Application by Fenwick Solar Farm Ltd for an Order granting development consent for Fenwick Solar Farm Project

The Examining Authority's second written questions and requests for information (ExQ2)

Issued on Wednesday 9 July 2025

Figure 8-5-2

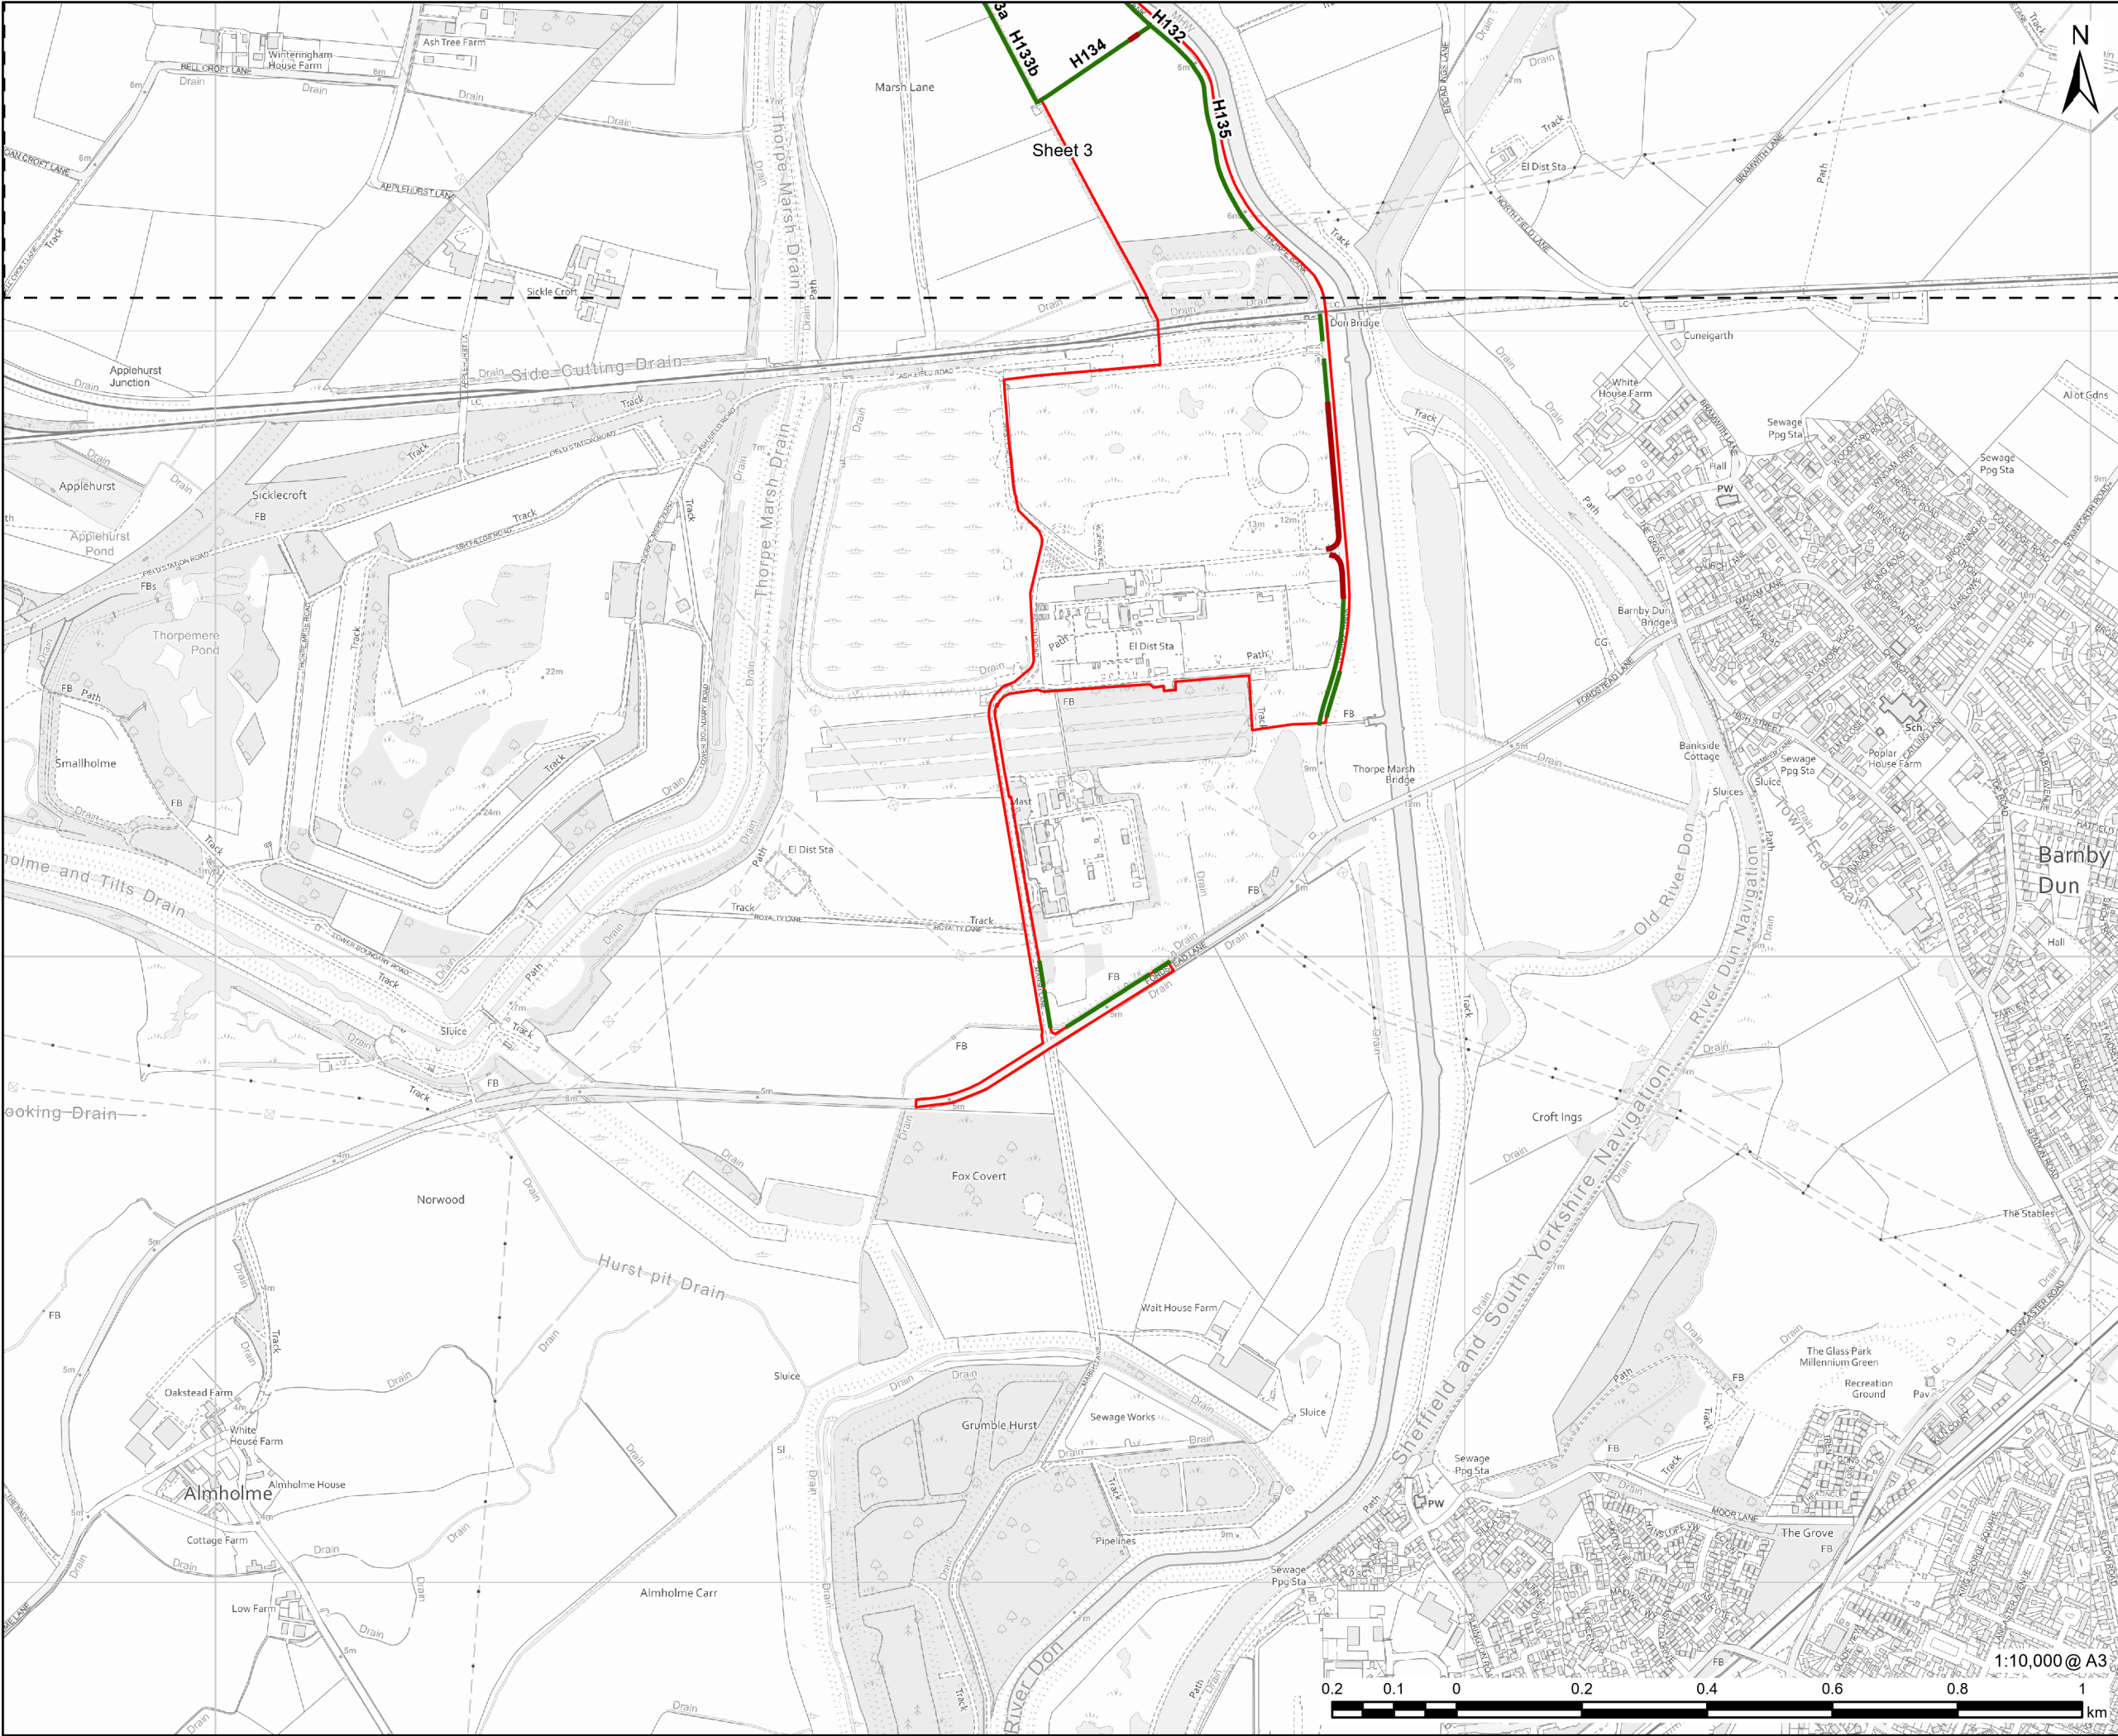
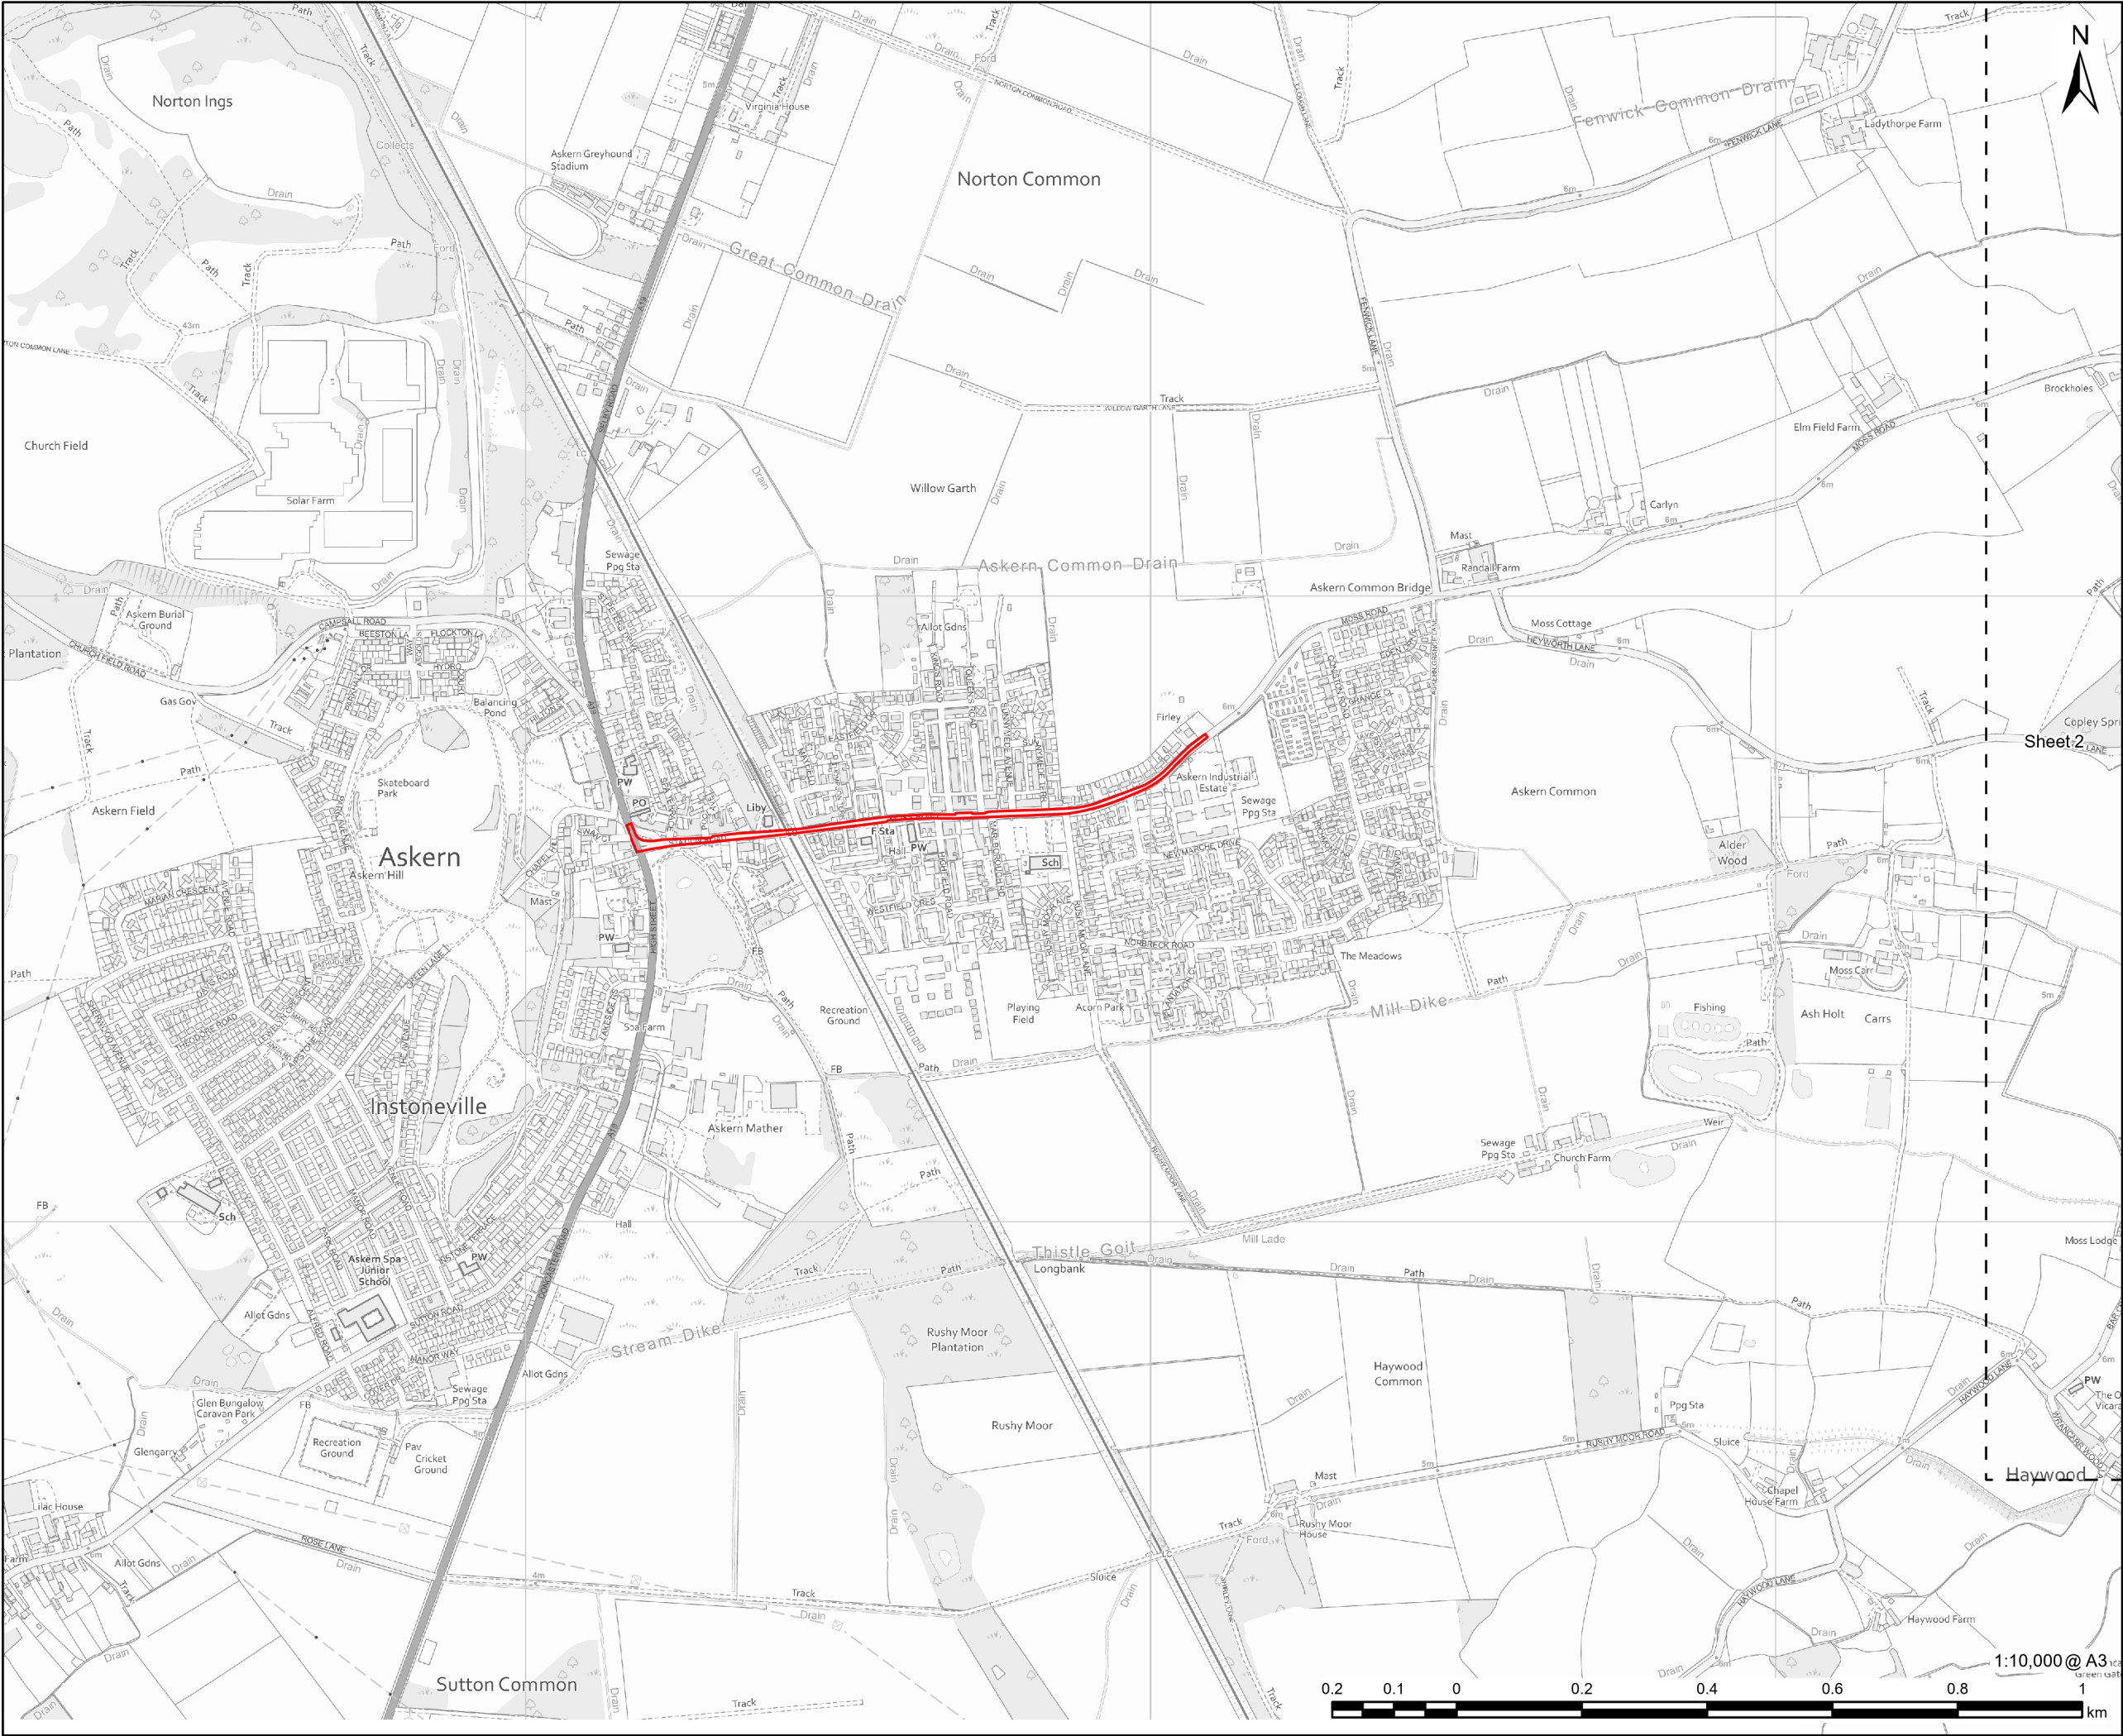
1.6.11	Applicant	Figure 8-5-2 of the Hedgerow Report [REP3-010] . Hedgerow 94 appears to have multiple sections removed as shown on figure 8-5-2 totalling approximately 77.5m in length which is approximately 53% of that total hedgerow. There is also proposed to be gapping up of this hedgerow. Please explain whether the hedgerow removal for H94 is temporary for the construction phase or the duration of the operation and in which case, how will gapping up align with this. Why is this called "N/A defunct" in table 2 under the heading "Important hedgerow Y/N".
